From: Simon Davis
Sent: 25 January 2019 14:29
To: [REDACTED]
Cc: Daniel Vick <Daniel.Vick@arun.gov.uk>
Subject: FW: Y/92/18/DOC- Further Drainage Supporting Info

From: Laura Gibbons
Sent: 25 January 2019 11:33
To: Simon Davis <Simon.Davis@arun.gov.uk>
Subject: RE: Y/92/18/DOC- Further Drainage Supporting Info

From: Rosie Foreman [REDACTED]
Sent: 24 January 2019 08:54
To: Simon Davis <Simon.Davis@arun.gov.uk>
Subject: Y/92/18/DOC- Further Drainage Supporting Info

Typical Road and Swale Section
Scale 1 : 25 at A1

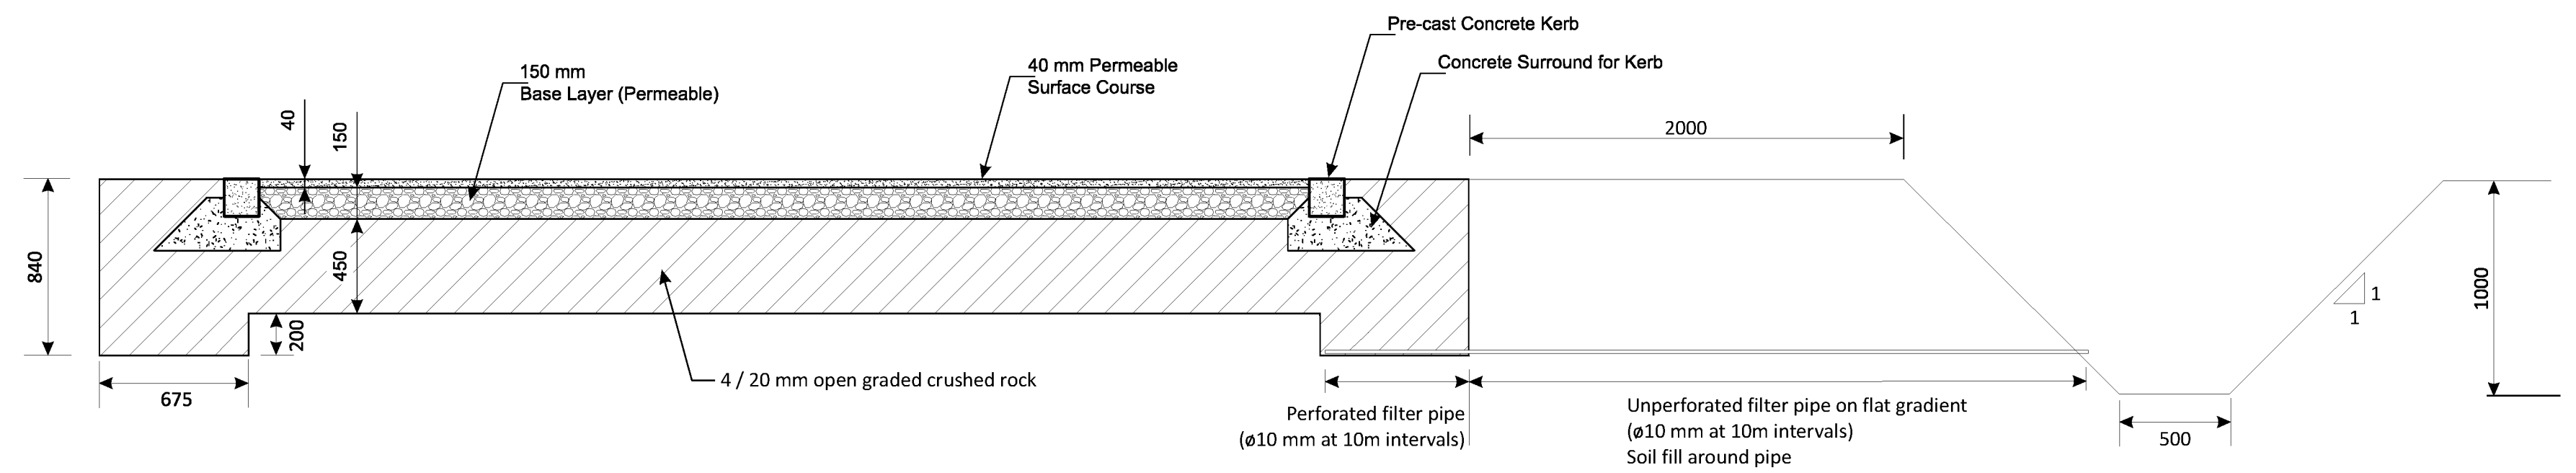
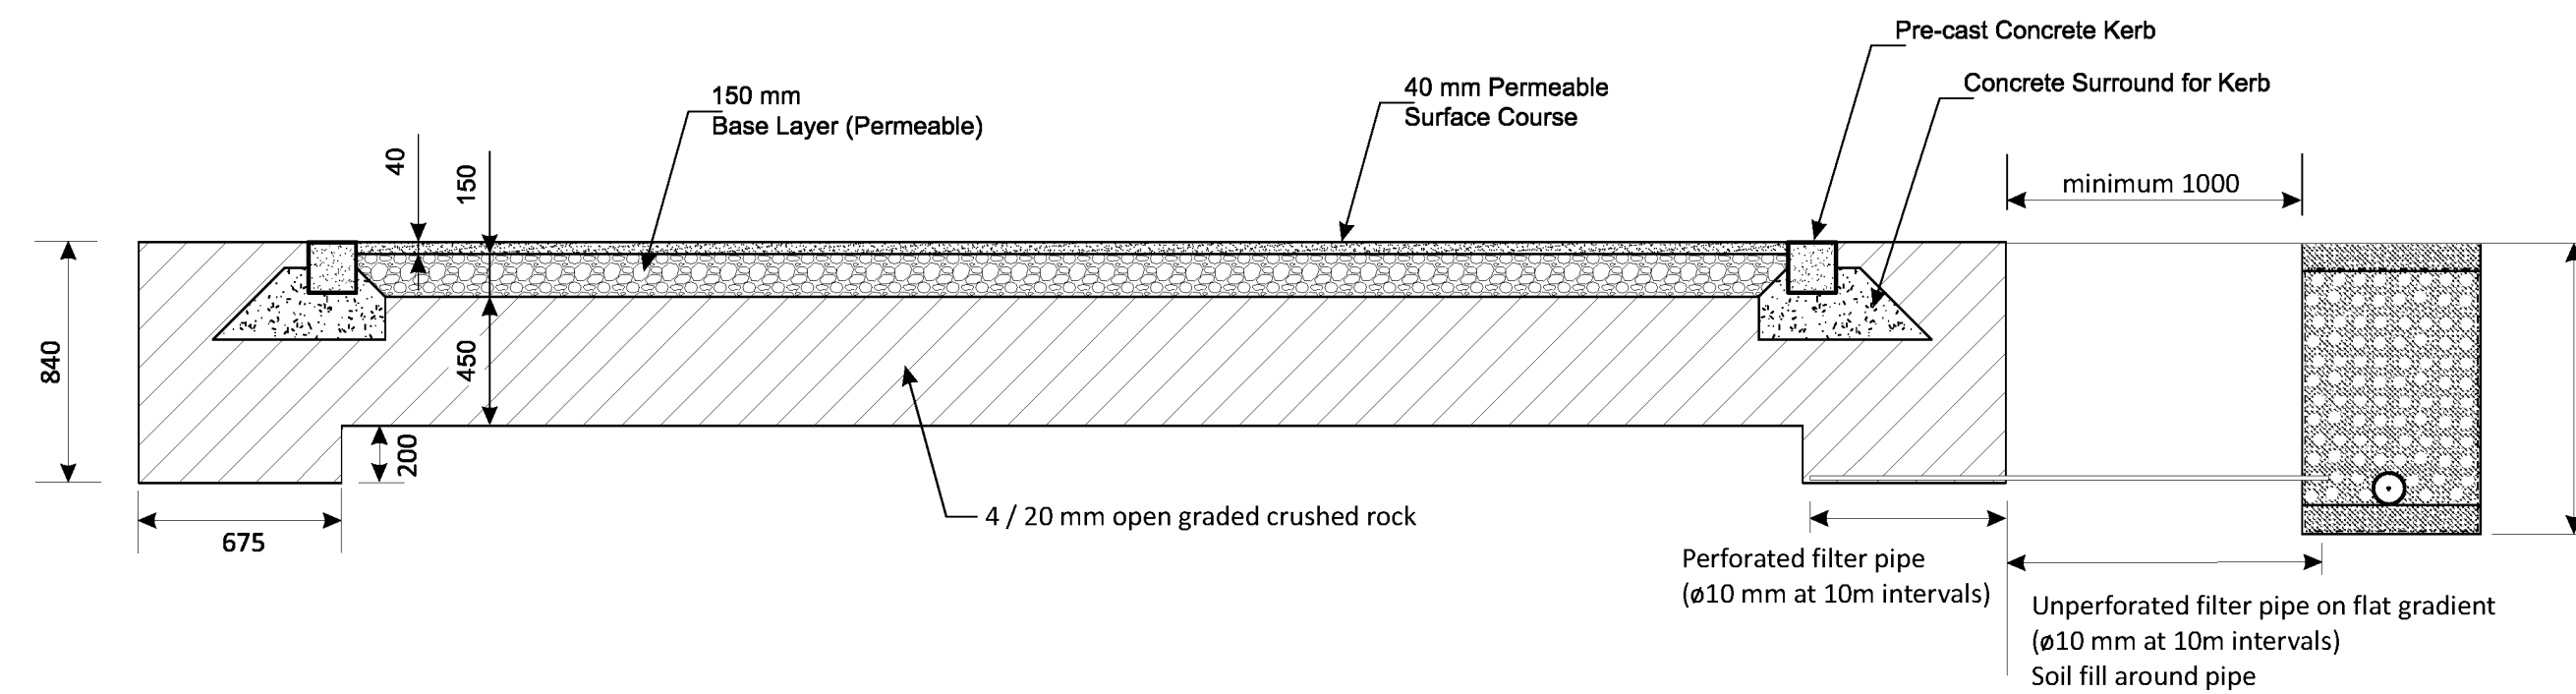
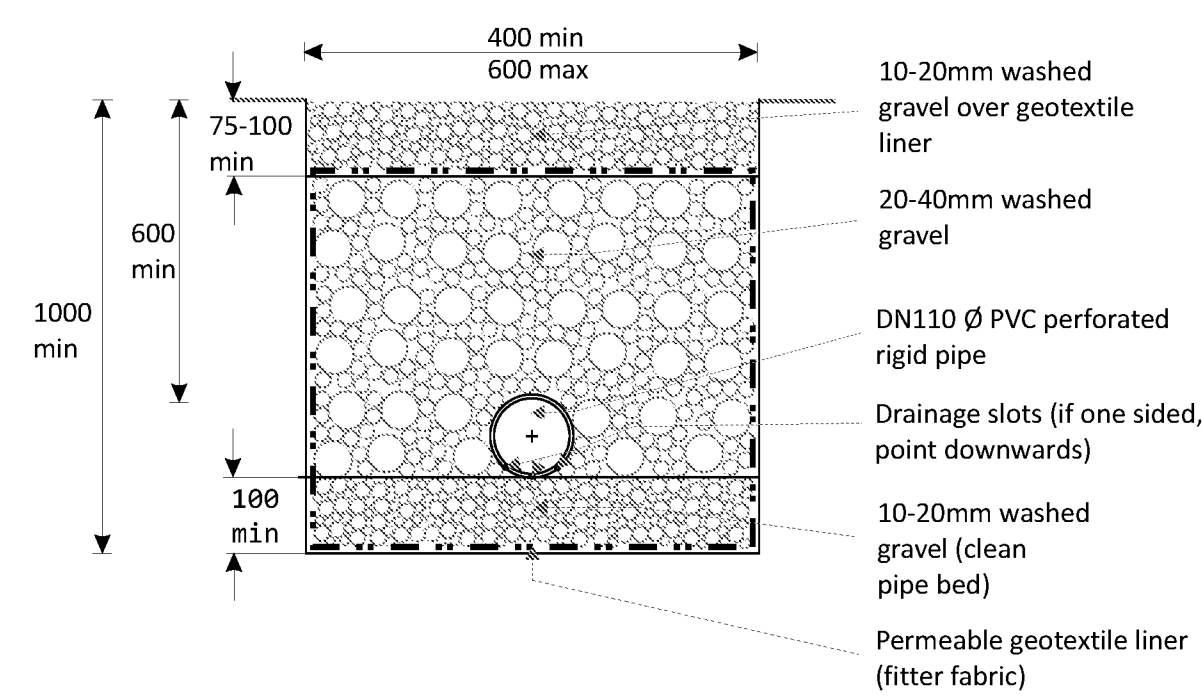
1. You are proposing on using permeable paving in areas where infiltration at 1m depth does not work. There is no proof submitted that demonstrates the drainage for the road has a point of discharge. You will need to complete infiltration testing at the formation level of permeable paving to determine if infiltration is viable. If it isn't a point of discharge to watercourse will be required.

9. The permeable paving construction details need to show permeable membranes are being provided. No details of the permeable surface course have been provided, and need to be.

10. Please detail what material will be used for the 150mm permeable base layer.
11. Sufficient construction detail drawings haven't been provided.
12. Sufficient details on layout plans have not been provided.

Eastern Bank of Reservoir

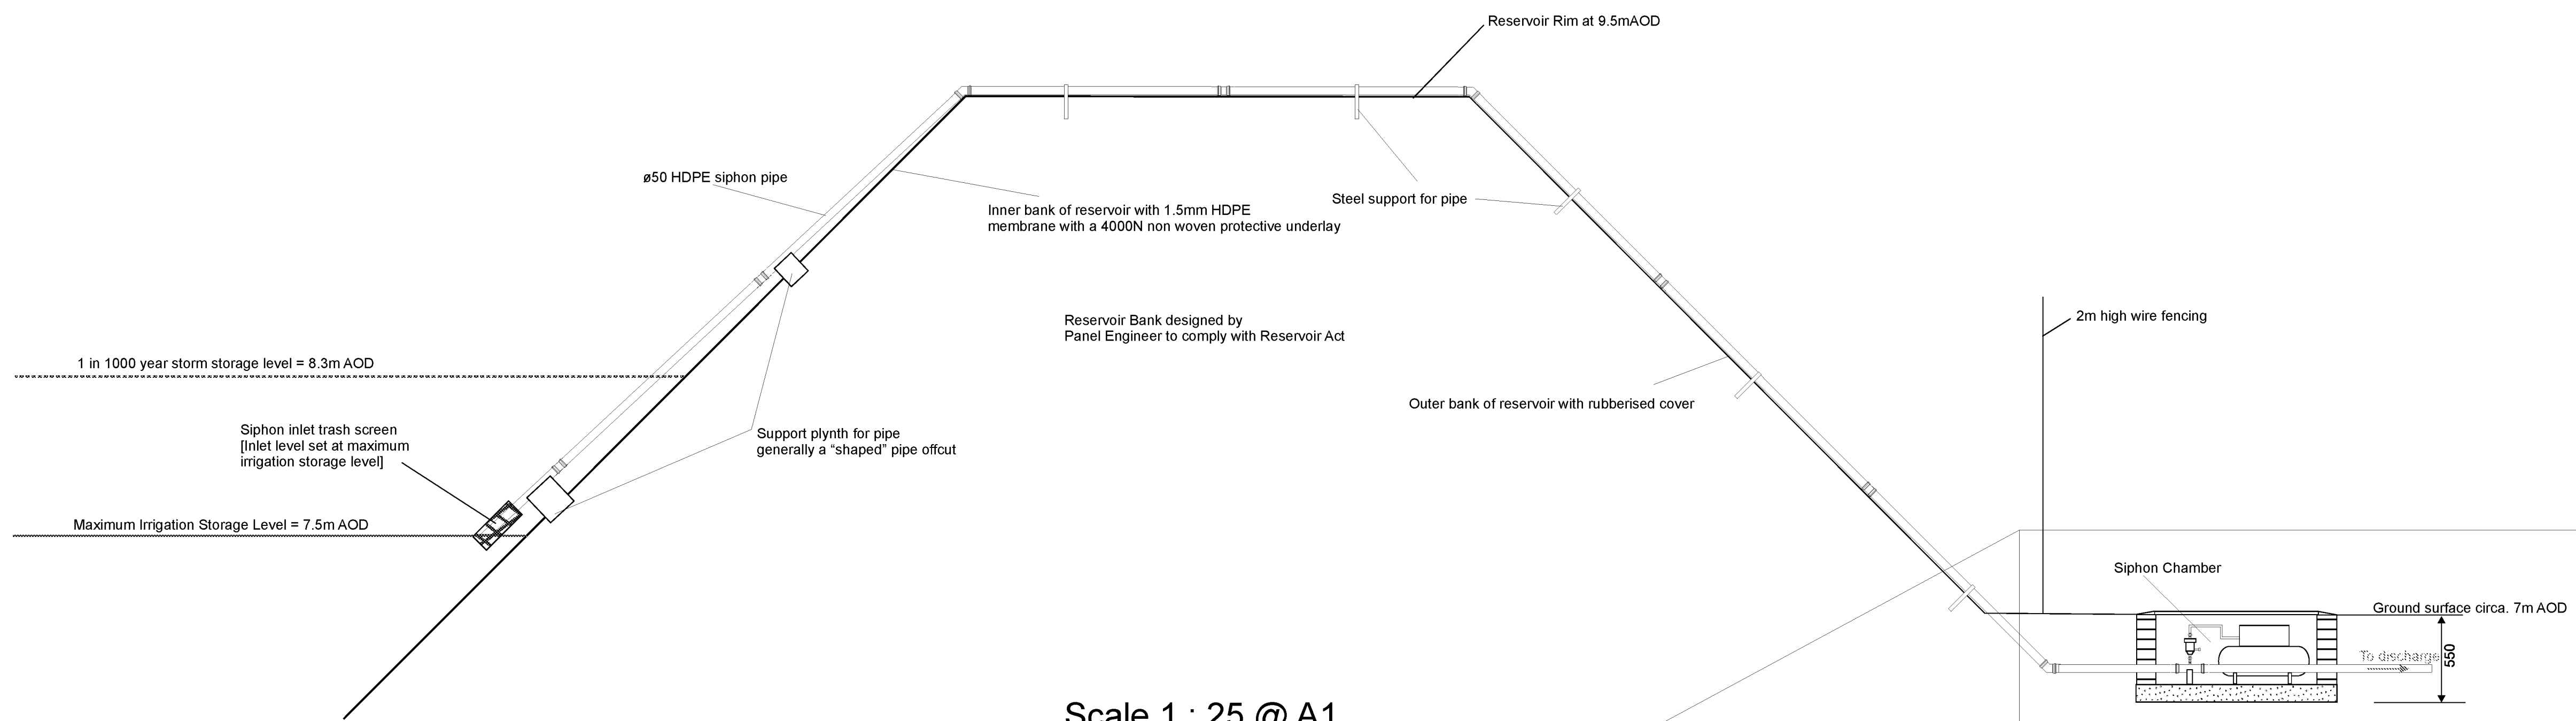
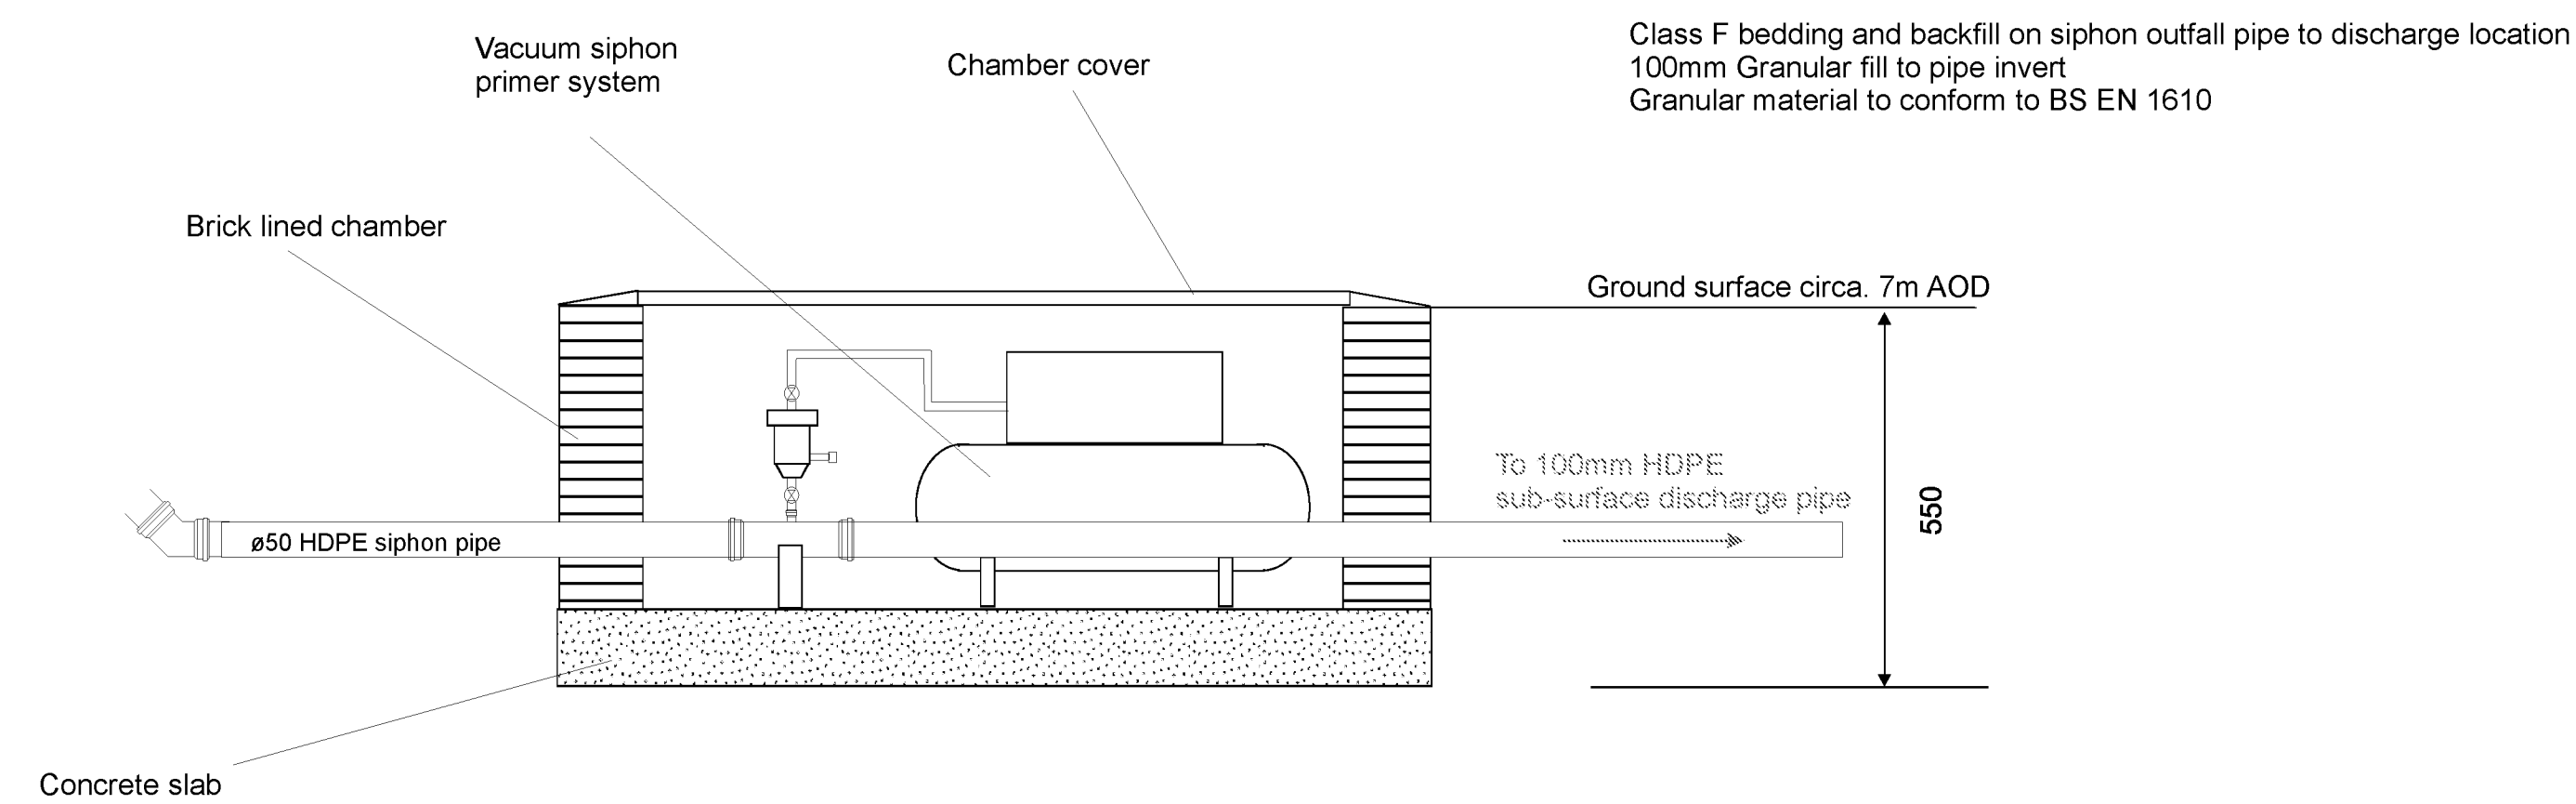
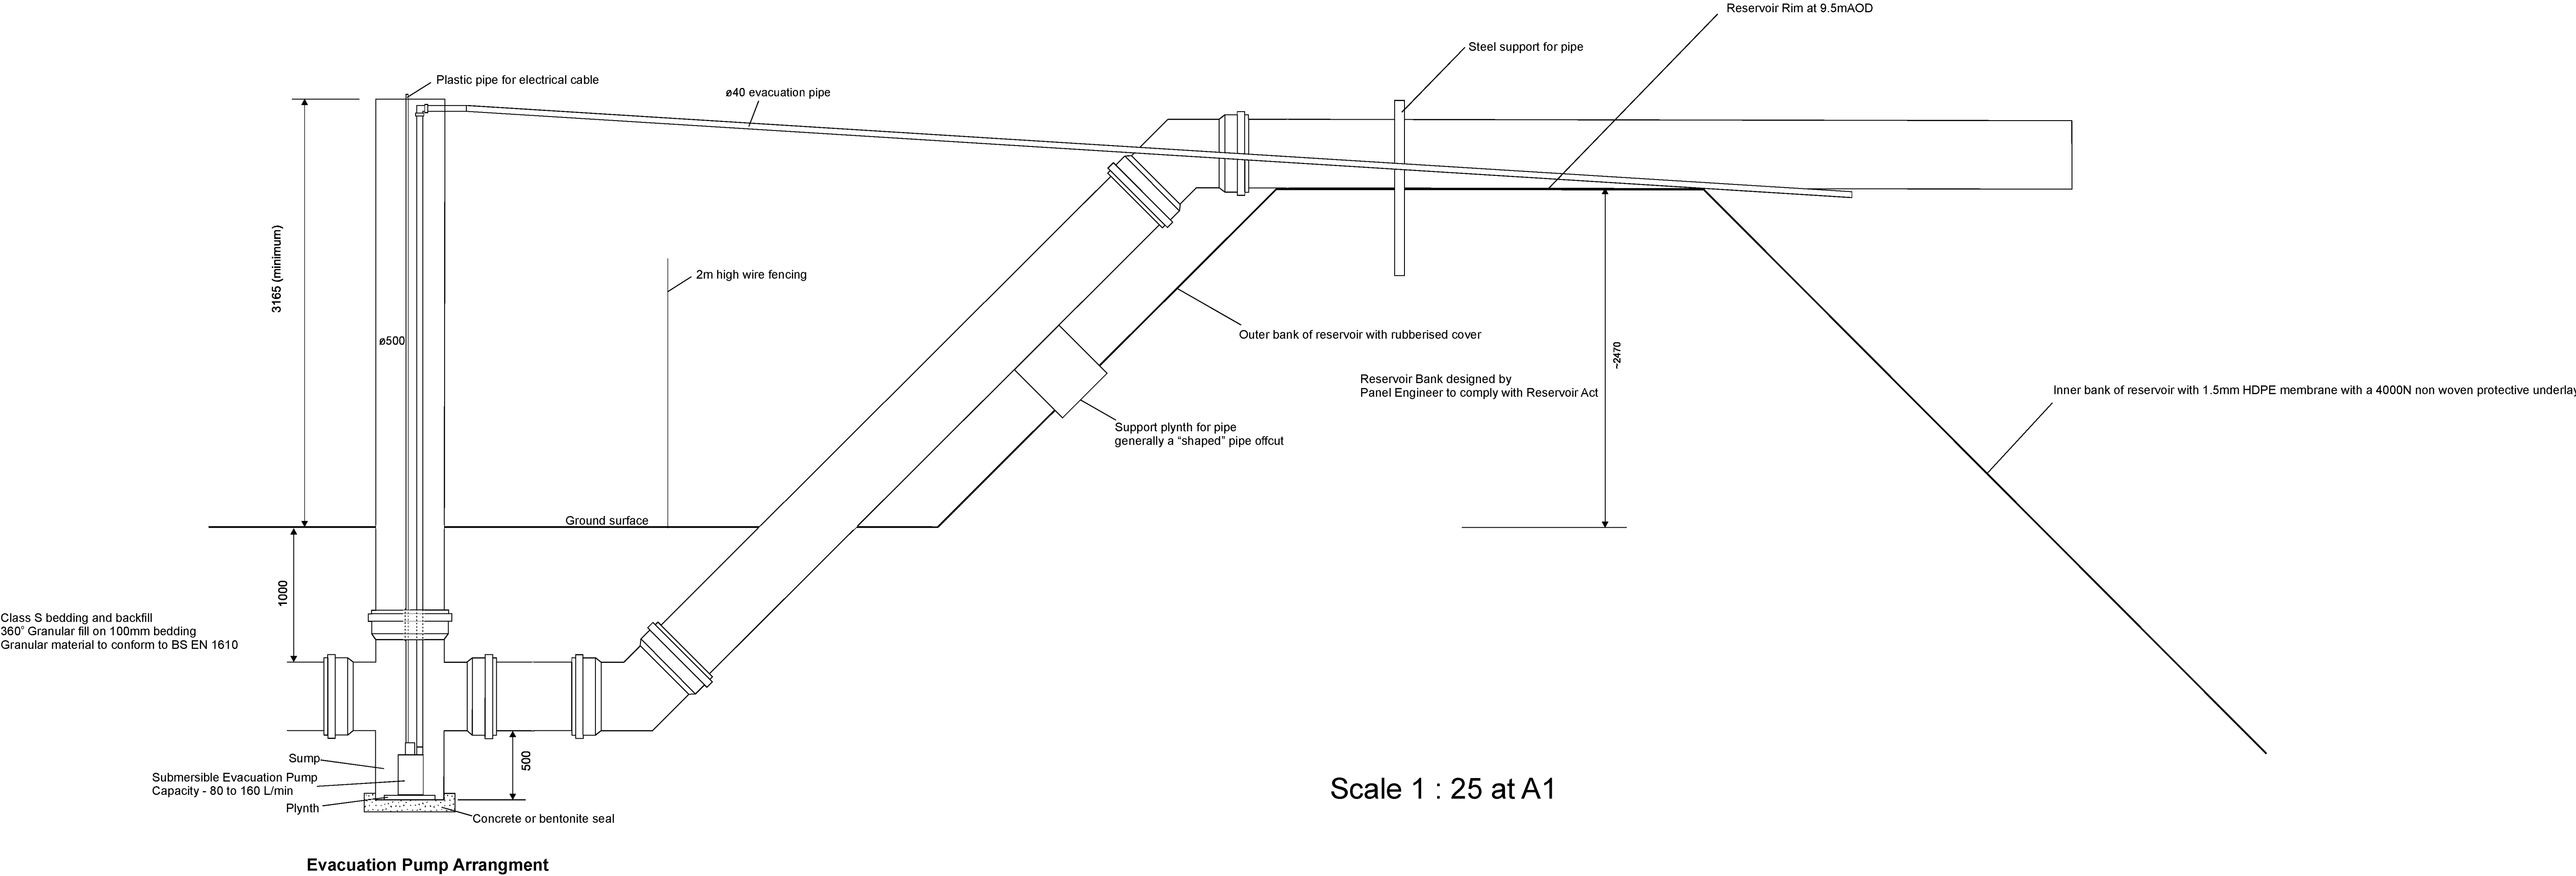
7. Full details of the attenuation basin will therefore need to be provided.
8. No dimensions have been provided on the attenuation basin and siphon drawings. This needs to be detailed.

L-Bloc® / 1.2m / Reinforced

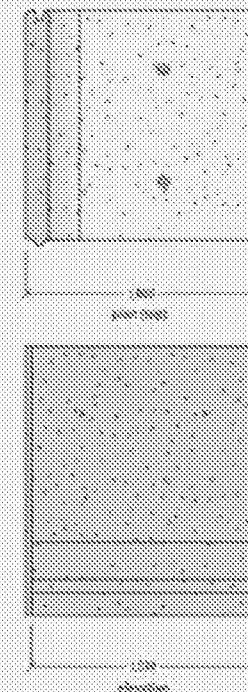
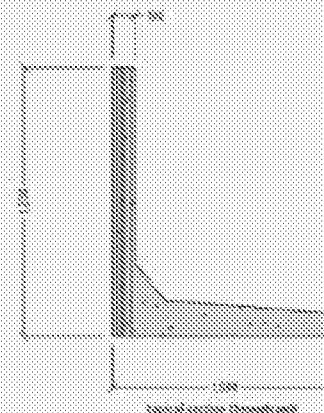
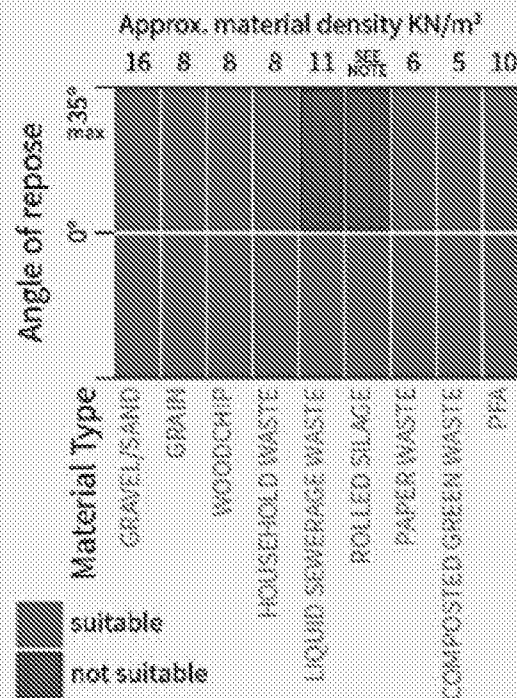
5. Insufficient details of the flood barrier have been provided. Please provide site specific drawings which include the concrete slab base and connectivity to the barrier.
